Application number: 2022/91911	
What is the application for?:	Erection of residential development consisting of 47 dwellings with associated h
Address of the site or building:	land at, Cliff Hill, Denby Dale, Huddersfield, HD8
Postcode:	YO19 5LP

Type of comment: An objection	
Do you wish your comments to be published on the website anonymously?	Yes
<p>Having taken time to study all the documents currently available (more seem to be being added!) I am writing to give comments primarily on the many drainage issues raised, as this seems very poorly understood by the developers. Other people have commented on many aspects which I also agree with, and I hope to make some comment on these later.</p> <p><b>EXISTING WATERCOURSE</b> The plans do not take account of an existing watercourse which runs from the paddock at Leak Hall Farm under the public footpath/track emerging under a hawthorn tree around where 'plot 26' is shown on the plans. The trough that this watercourse emerges into is now obscured by brambles, and has been missed in site surveys. It then disappears back underground. We suspect that it runs down to join the watercourse/culvert emerging behind the new houses on Leak Hall

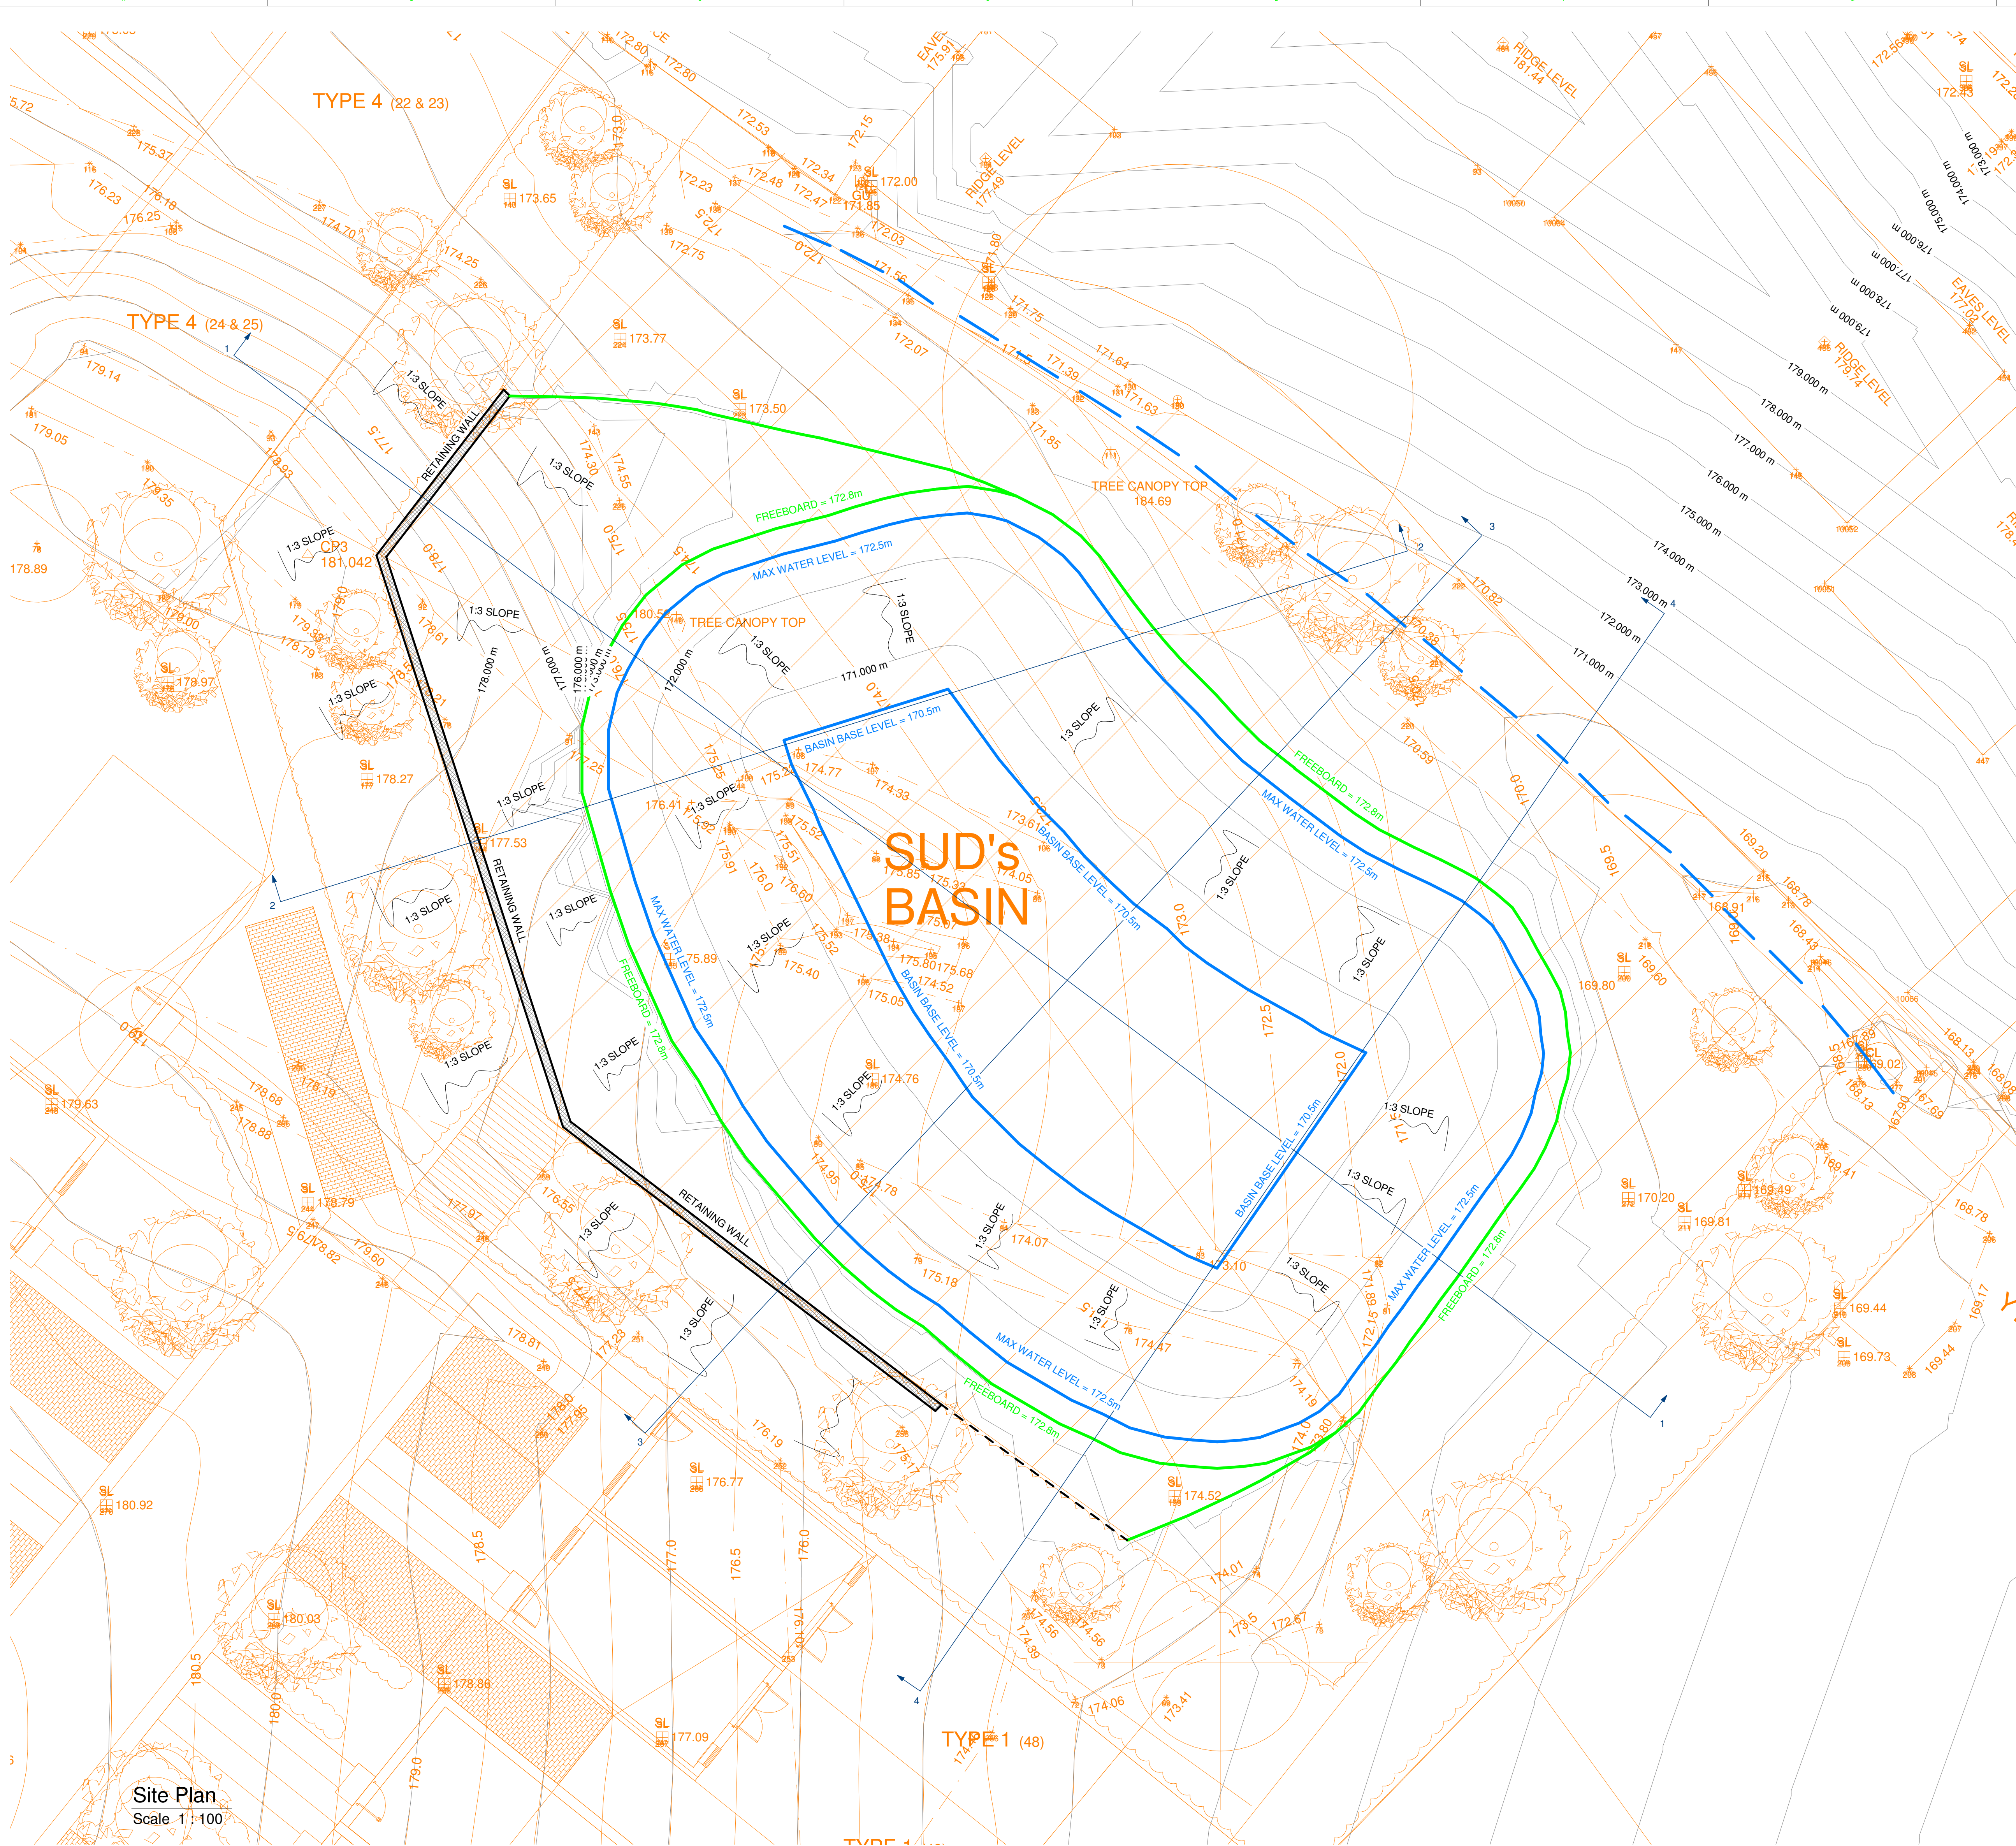
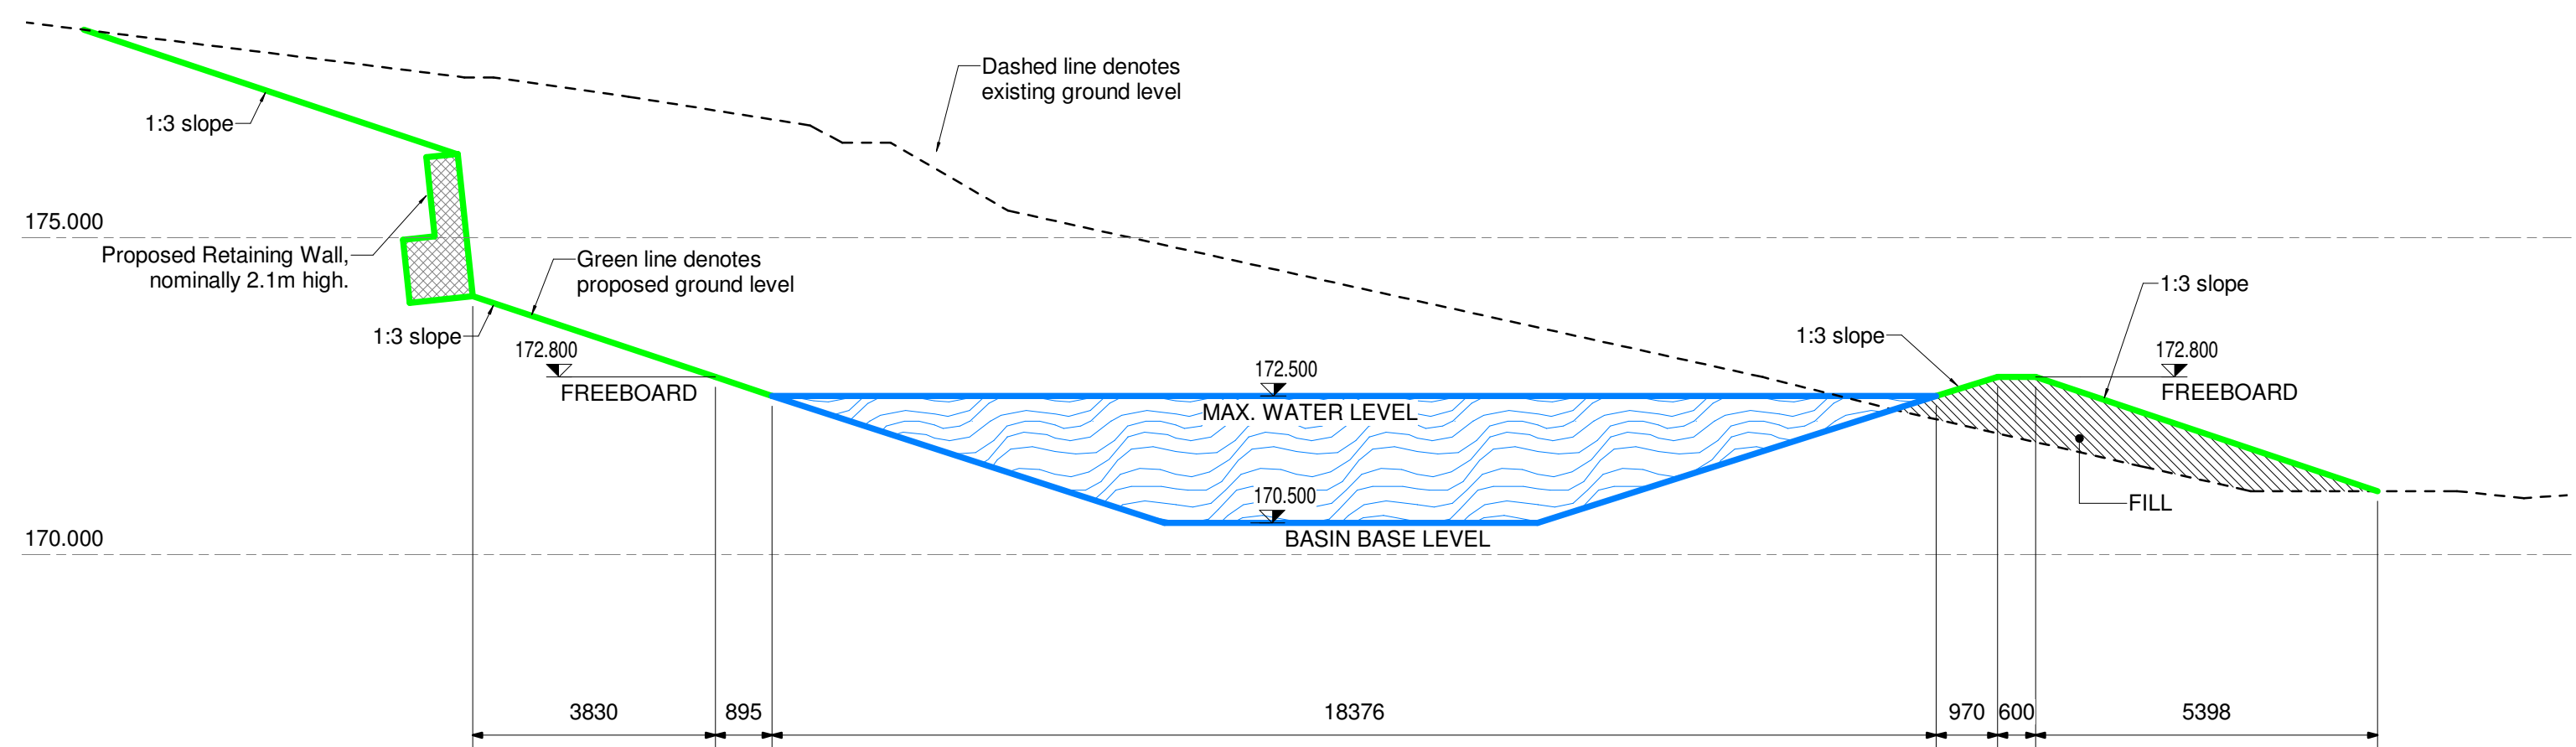
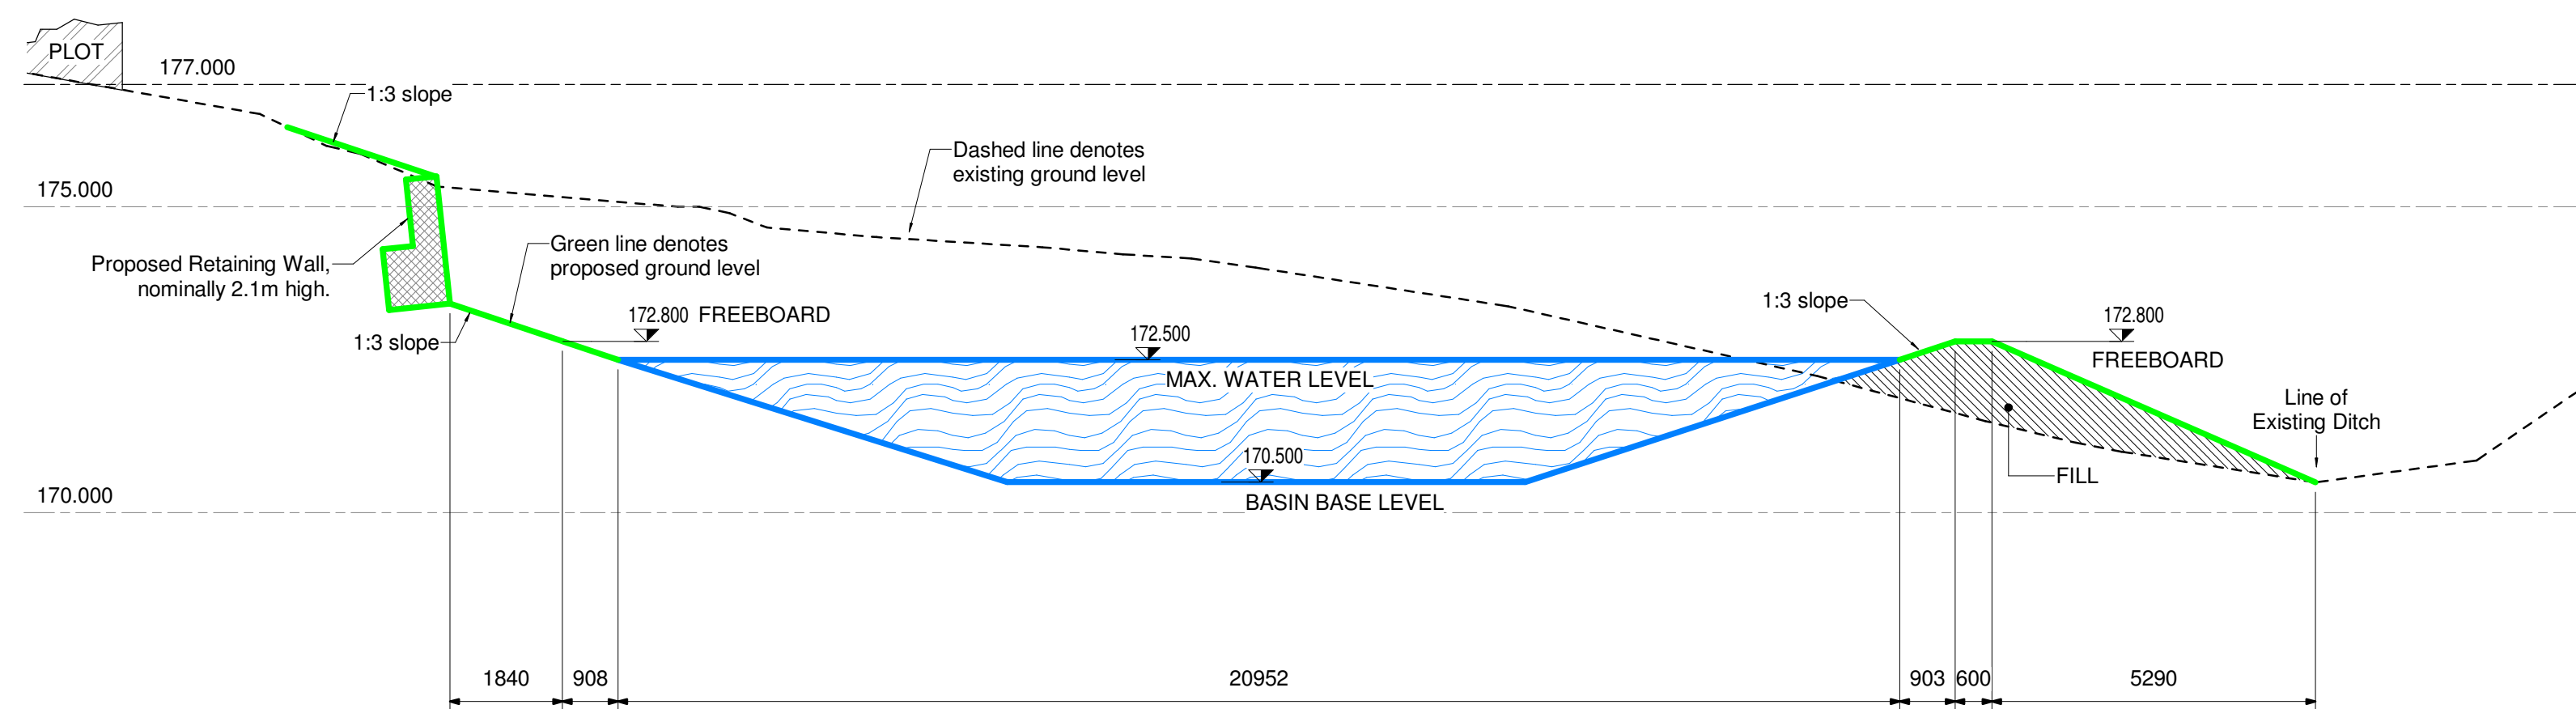
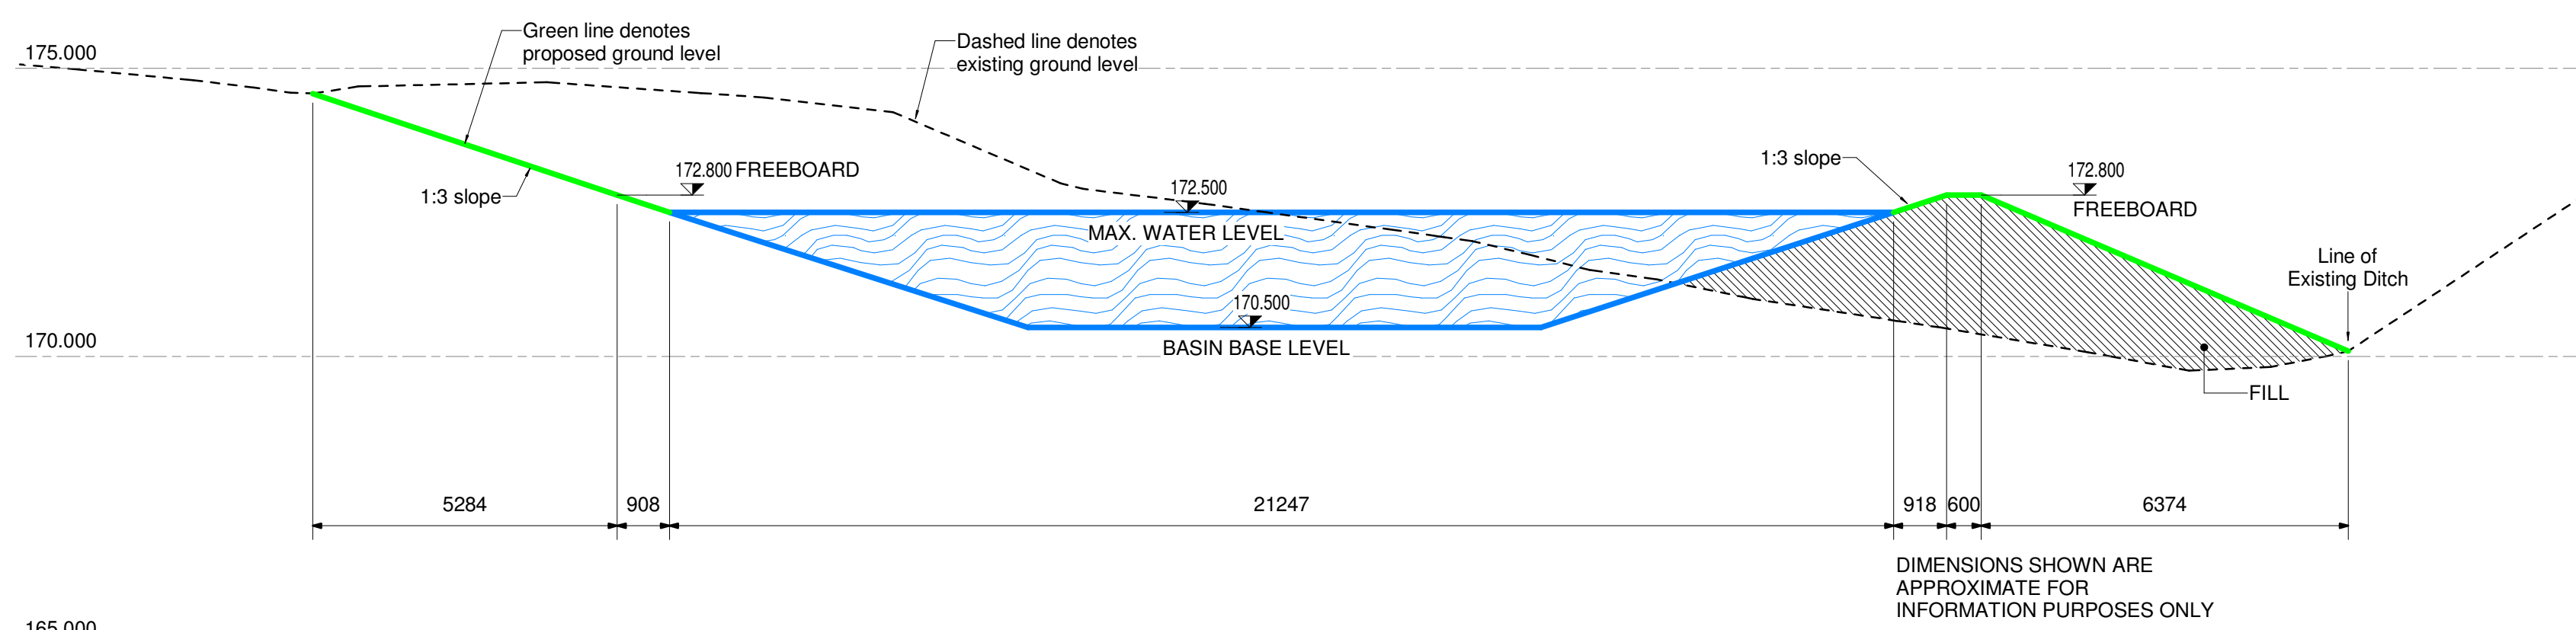
**SUSTAINABLE DRAINAGE:** The SUDS feature raises several issues. The design does not seem likely to form a useful or attractive public open space – as claimed – nor to be a good sustainable drainage solution. The basin has a completely flat bottom, so will always be boggy, if not wet; it may be below the water table. It appears that the basin is surrounded by 1 in 3 slopes and retaining walls, and inlet features. This will limit its use by residents, and if it retains water, could be unsafe for recreation. The landscaping appears to consist of two trees! And will the basin need to be close mown to ensure it remains available to hold maximum water and does not become full of brambles and scrub – who will do this and pay for it?

When full, the water is retained by an engineered bund across the slope, and does not sit within the natural landform. There are houses immediately below this bund, which when full will be holding back 2 metres depth of water – this seems very risky in the short term, when all the land has been disturbed, and in long term. What happens if the bund overflows? Or if it is weakened by foxes, rabbits etc? also, the figures used for run-off calculations are said to be based on a greenfield site, but after the ‘excavation & fill solution’ this will all be made ground not greenfield, with no root zone, no fissures, less percolation and so greatly increased run-off. If the figures are even slightly wrong and the basin is not big enough – this will be a disaster.
